Portishead Branch Line (MetroWest Phase 1)

9.15 ExA.CAH1.D3.V1 – Applicant's Oral Case and response to Representations at the Compulsory Acquisition Hearing 1 (CAH1)

The proposed Portishead Branch Line (MetroWest Phase 1) Order

Applicant's response to Representations at the Compulsory Acquisition Hearing Held on 4 December 2020 at 10am

2.48 - Ashton Vale Road Pedestrian Ramp Design Plan

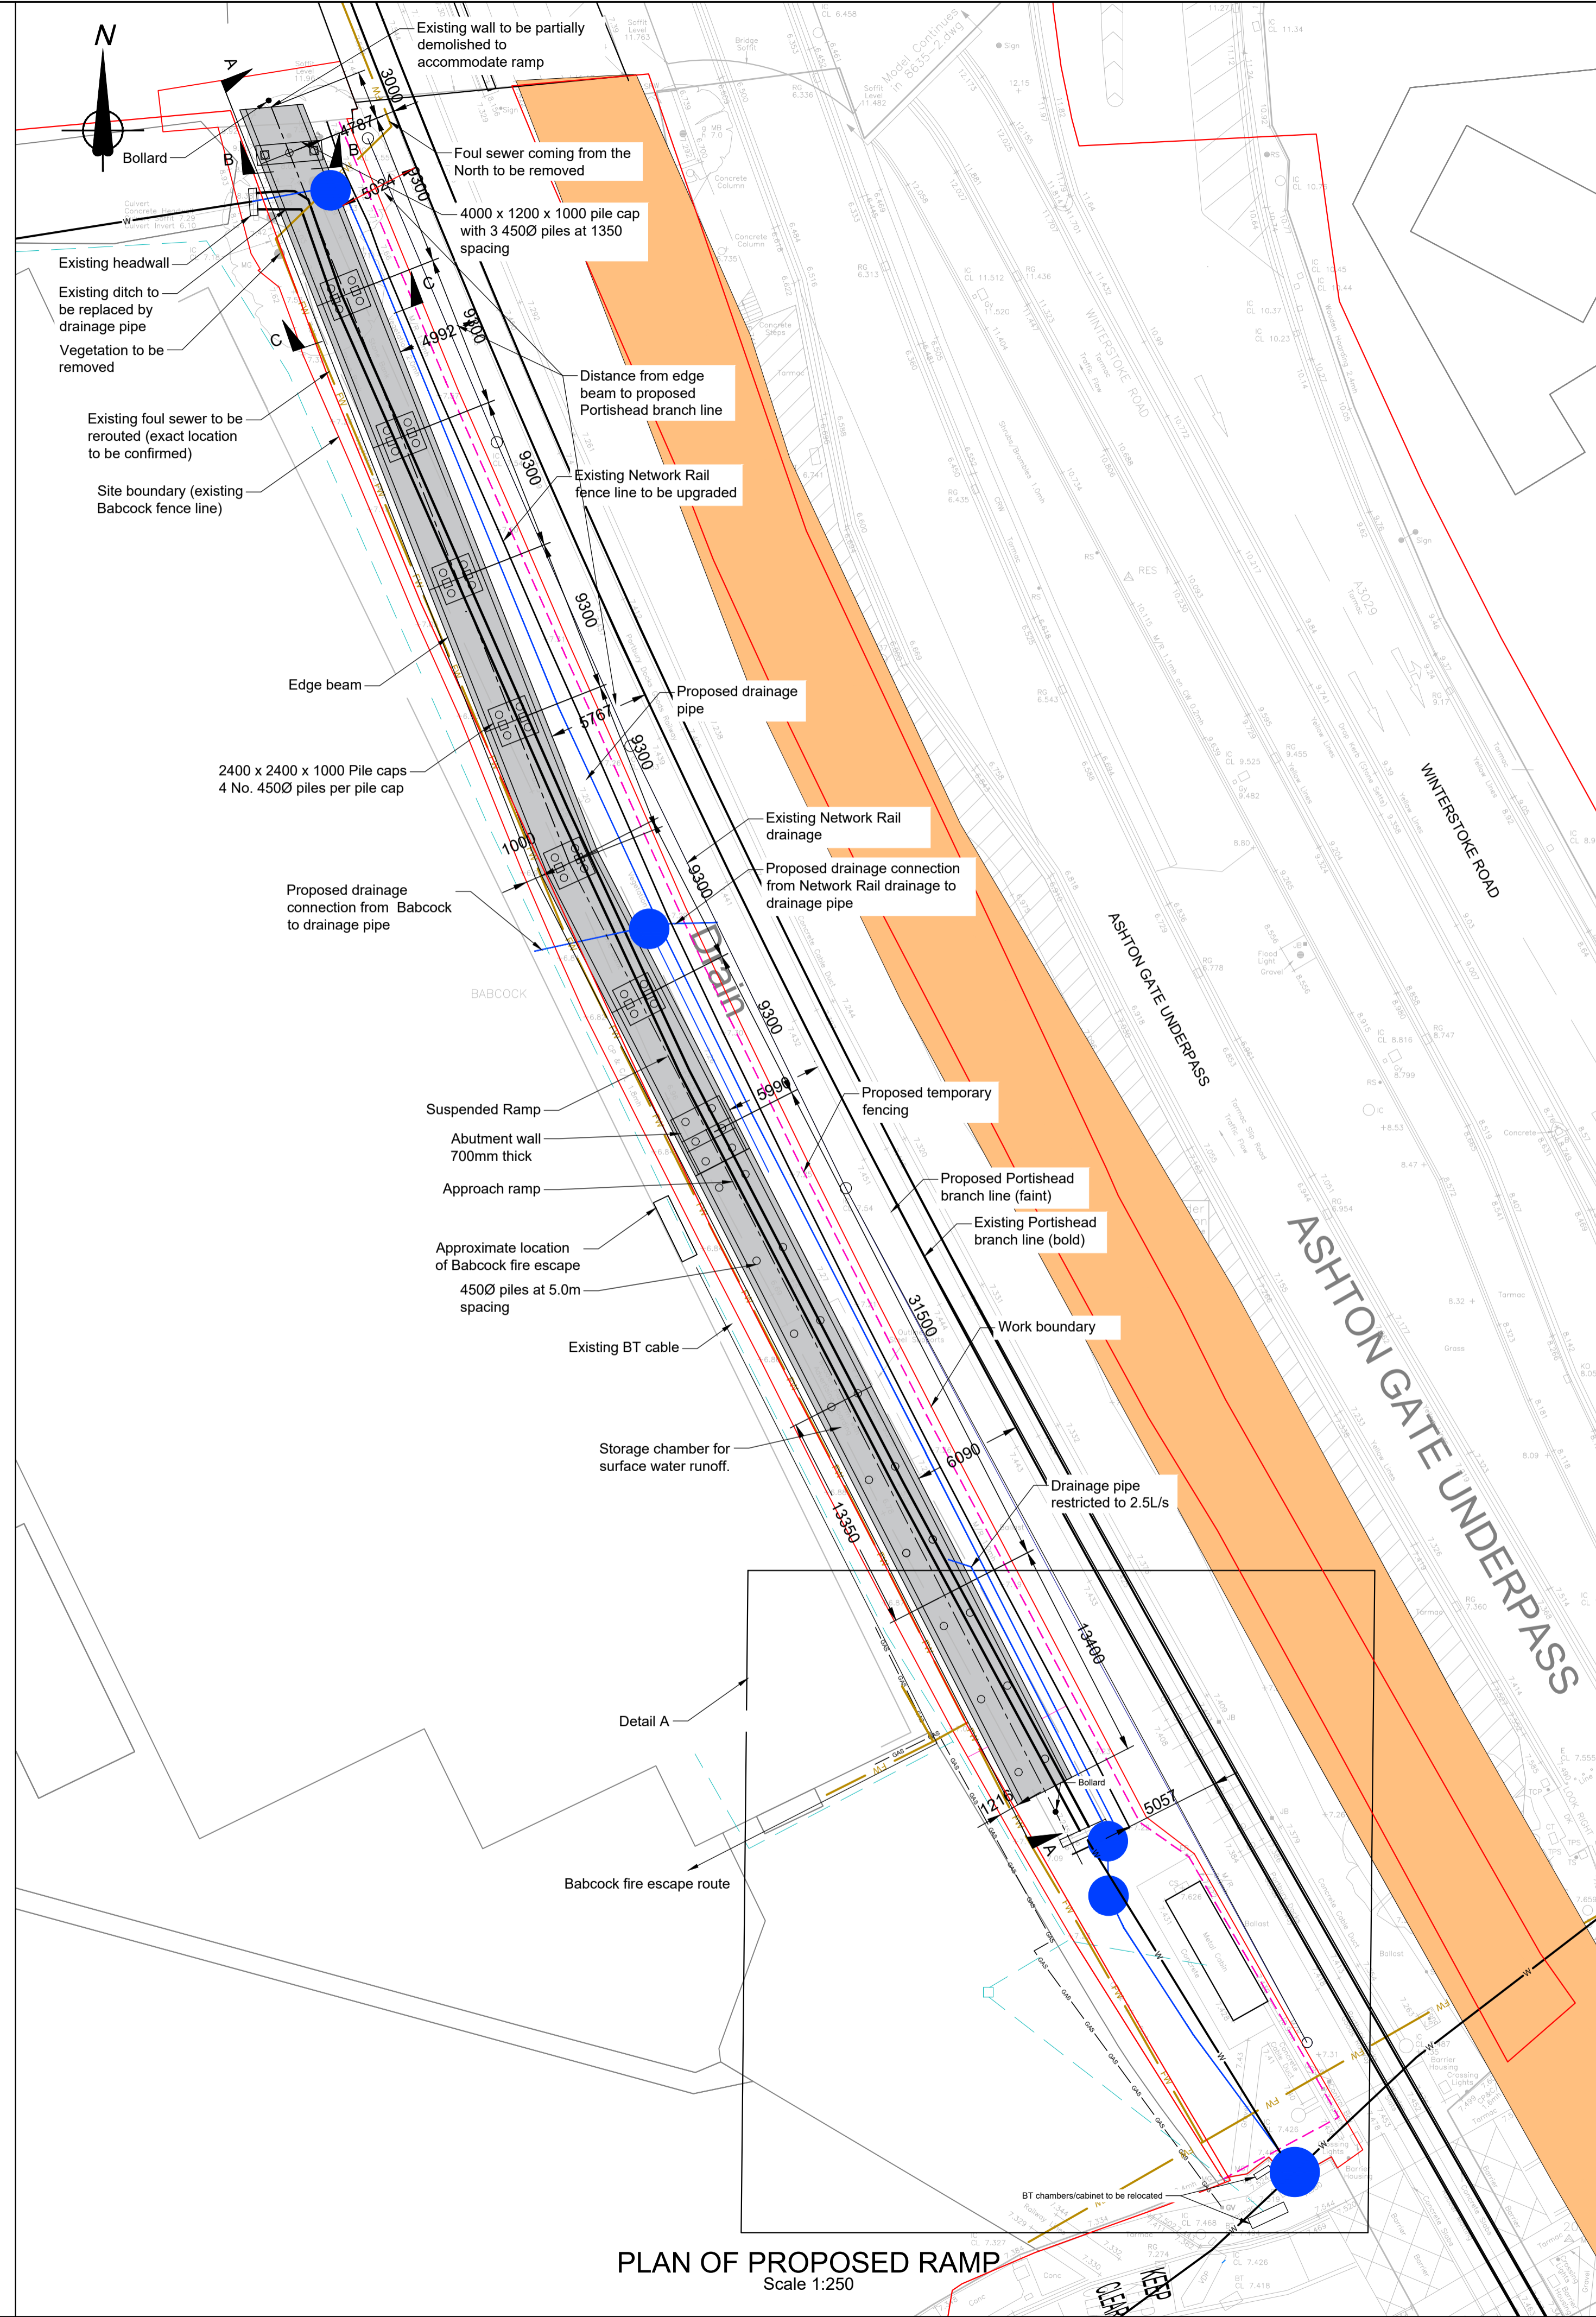
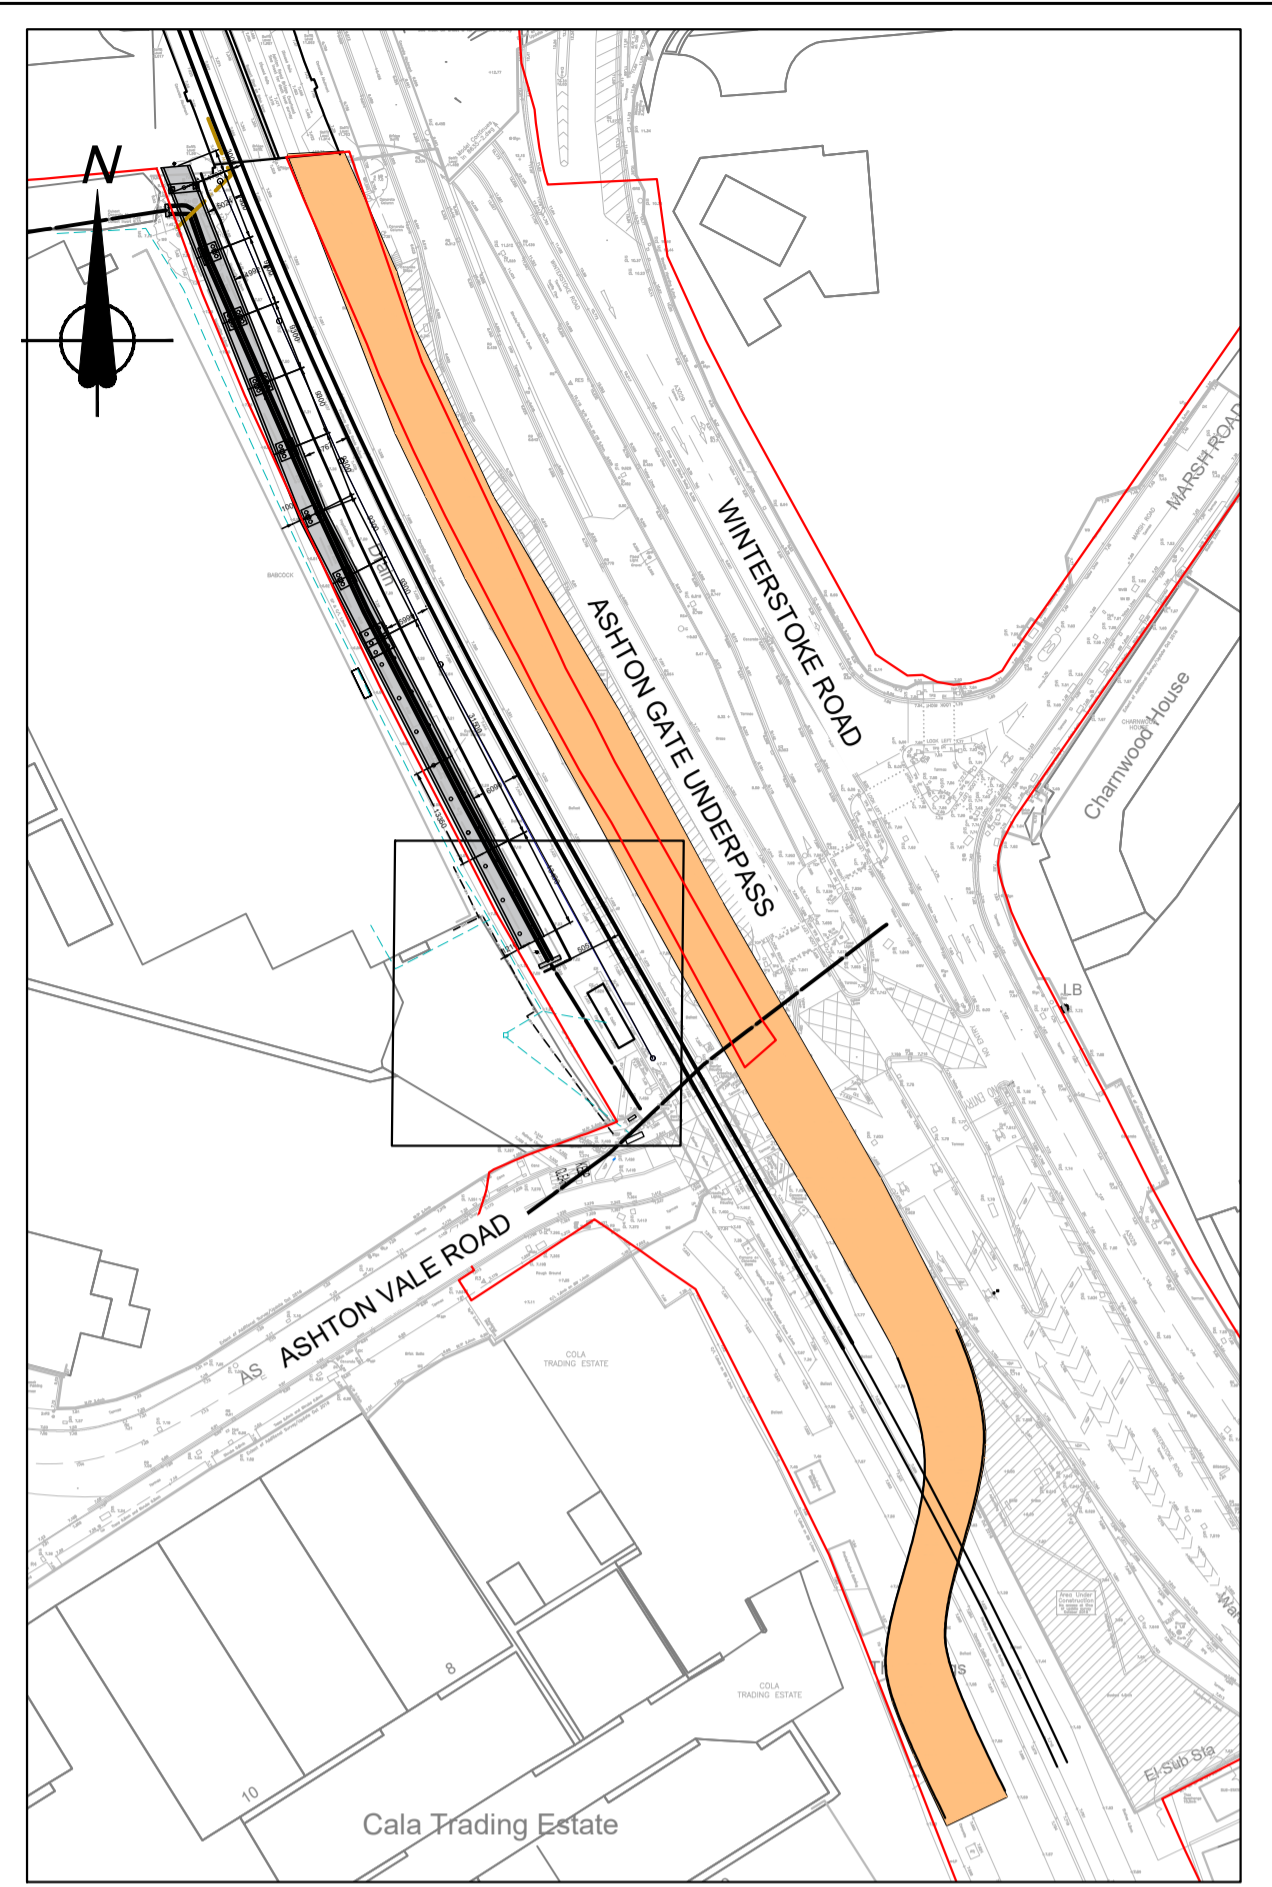
2.	ExA Panel	In relation to Work No 27: This relates to the provision of an alternative crossing by Ashton Vale Industrial Estate. There is uncertainty about whether this work will or will not be provided. The Applicant's response in a letter to Babcock on 21 August stated that the crossing would follow later if built. How does this meet the test set out in s122? If the ramp is built later could this not be done under Network Rail's permitted development rights?	In relation to the test in s122, the land required for the bridge itself is held by Network Rail. Prior to submission of the Application, there was a possibility that the Applicant needed new rights over land comprising the Babcock Estate. This was because the Applicant felt it could not meet the tests in s122 in relation to Babcock's land. The ramp improves accessibility for pedestrians and cyclists at times when the Ashton Vale Road level crossing is closed due to MetroWest services crossing Ashton Vale Road, but does not provide so significant an improvement that the need for it is sufficiently compelling to justify compulsory acquisition of new rights over Babcock's adjacent land. In terms of land in the Order lands on which this work would be located, it is existing operational land held by Network Rail. Network Rail's land is in the Order in any event and the Applicant has already adjusted the order land boundary to remove Babcock's land. As the work is to facilitate an improved highway network or permissive way it may be that	The Applicant has no further representations to add.

Ref:	Question/ Representation by:	Questions/Issues Raised at the CAH	Applicant's Response at the CAH	Applicant's Written Response
			development rights could not be relied on. The Applicant felt it was better to keep the work in the Order to ensure that is has the planning permission ready to construct the ramp.	
			The Applicant did not feel it however there was a compelling case sufficient to seek powers to divert utilities serving Babcock in to Babcock's land. In the face of Babcock's likely objection to powers being sought over its land, it was felt appropriate to not seek those powers. There are planning justifications to keep the work in the Order as, if agreement is reached with Babcock, then the ramp would be provided. Bristol City Council is keen for the ramp to be provided for pedestrian access to Ashton Vale Road at times when the level crossing is closed due to the increased number of train movements arising from the MetroWest services. However the need for the ramp is not so compelling that it justifies seeking compulsory new rights over Babcock's land.
